Harnett County
Application Tracking Individual Step Maintenance

Application number : 18 50043325
Application type : CP ADD & ALTER RESIDENTIAL
Revision number :
Path/Step/Seq/Agency . . . : A 20 00 ENVIRONMENTAL HEALTH
Date submitted, resulted . . : 30918 _____
Status code (F4) : _____
Reviewed by (F4) : _____
Revised est cpl date : 30618
Copies of plans : _____

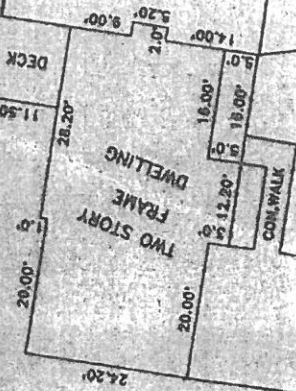
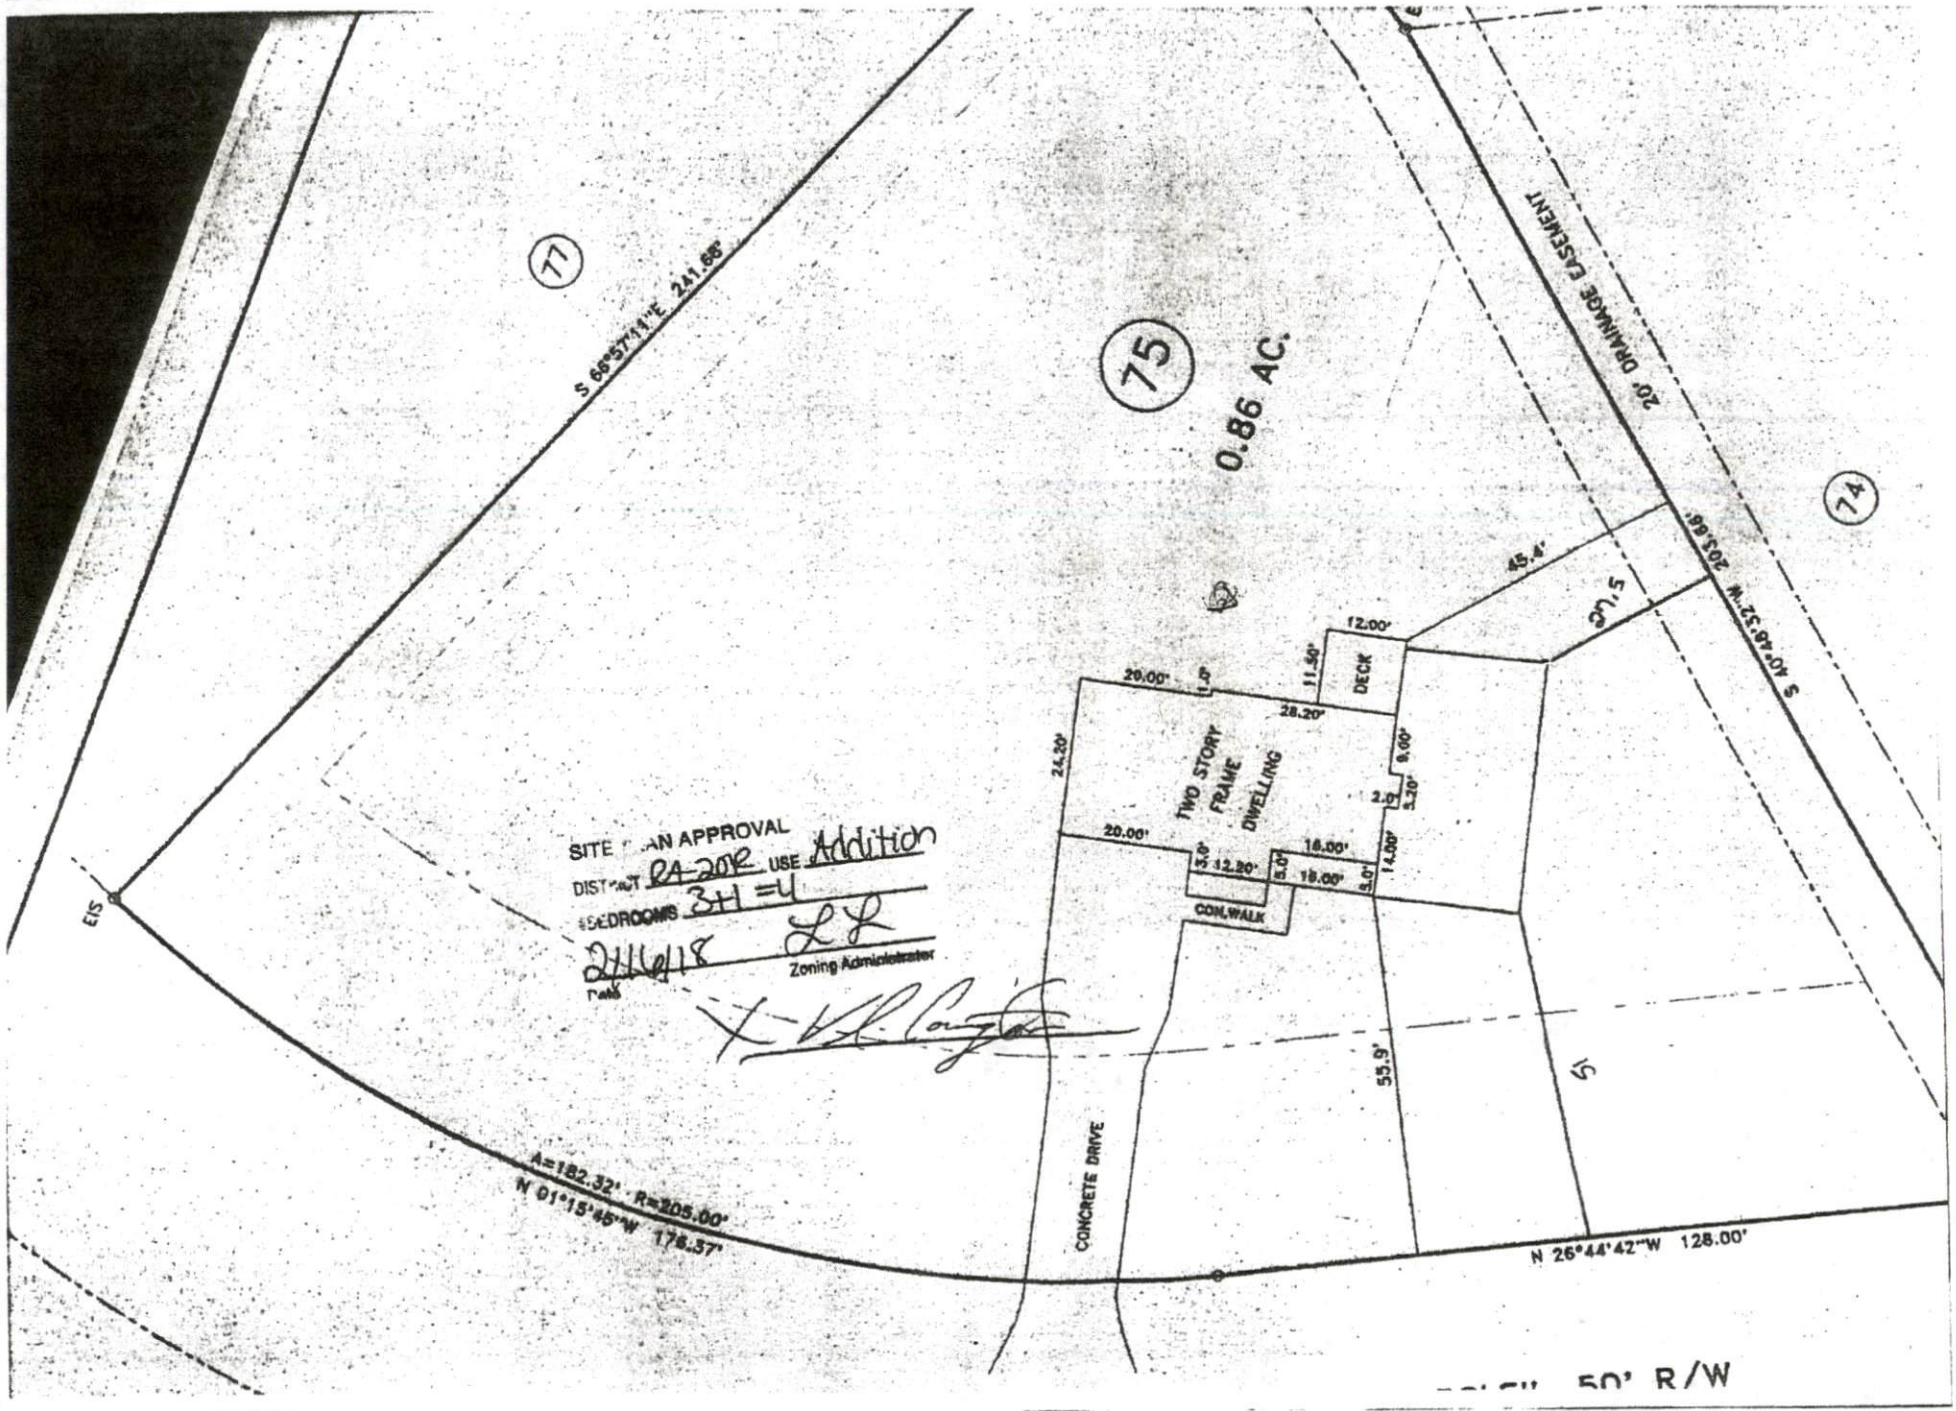
Opt	Seq	Comments
-	1.000	PER OLIVER WILL REVISE SITE PLAN- NO INCREASE IN BEDROOMS REDUCE SIZE OF KITCHEN TO NOT ENCROACH ON SEPTIC TANK
-	2.000	
-	3.000	
-	4.000	
-	5.000
